Appeal Decision

Appeal Ref: 6003933

1A Villier Street, Uxbridge, Hillingdon UB8 2PU

- The application sought planning permission for *change of use from Industrial to MOT Centre (Sui Generis) along with widening of drop kerb along with installation of new wooden door and new front door* without complying with a condition attached to planning permission Ref 76186/APP/2024/3188, dated 3 April 2025.

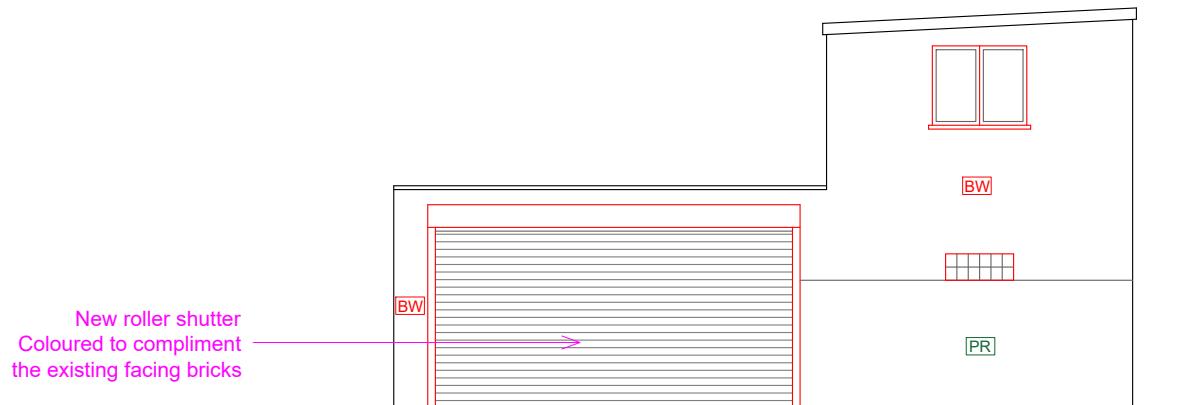
2. Full planning permission was granted in 2025 for change of use from Industrial to MOT Centre (Sui Generis) along with widening of drop kerb along with installation of new wooden door and new front door (reference 76186/APP/2024/3188).
3. The appellant seeks to amend the approved elevations to replace the wooden front door with a roller shutter.
4. The application form states that the development was started in May 2025. At the time of my site visit, construction had taken place and I was able to see the roller shutter.
5. Accordingly, the main issue is whether the roller shutter preserves or enhances the character or appearance of The Greenway Conservation Area.

9. The Villier Street façade of appeal property is predominantly brick, consistent with facades present elsewhere in the CA. Its historic fenestration, removed as part of the development, was in keeping with that of nearby premises in terms of form, scale and materials. In this regard, the property contributed positively to the CA's character and appearance and its significance as a designated heritage asset.

10. The installation of the roller shutter has resulted in the removal of some historic brickwork as well as the loss of traditional fenestration. The quantum of brick removed is relatively modest in the context of the wider property and surrounding built environment. However, in combination with the modern design of the roller shutter which contrasts starkly with the architectural composition of the property, the loss of the historic materials has diminished the character and appearance of the appeal property. This is irrespective of the slim line form and colour of the roller shutter. Consequently, although the development is of a small scale and has a visual impact which is reasonably limited in extent, it detracts from the character and appearance of the CA.

12. The Framework and the Planning Practice Guidance require the category of harm to be explicitly identified, and the extent of harm within that category to be clearly articulated. Given the scale of the development, and mindful of the other materials present in the immediate vicinity of the appeal site, I find that the harm to the significance of the CA is at the lower end of the spectrum of less than substantial harm. Nonetheless, the harm is of considerable importance and weight.

16. For these reasons, I conclude that the roller shutter does not preserve or enhance the character or appearance of the CA. In this regard, it is contrary to the relevant provisions of Policies BE1 and HE1 of the Hillingdon Local Plan: Part One – Strategic Policies (2012), Policies DMHB 1, DMHB 4, DMHB 11 and DMHB 12 of the Hillingdon Local Plan Part 2 – Development Management Policies (2020) and Policies HC1 and D3 of the London Plan 2021. Among other things, these policies seek a high quality of design which conserves and enhances the Borough's distinct and varied environment, makes a positive contribution to the local character and distinctiveness of an area and sustains and enhances the significance of heritage assets.

1. The appeal is dismissed.
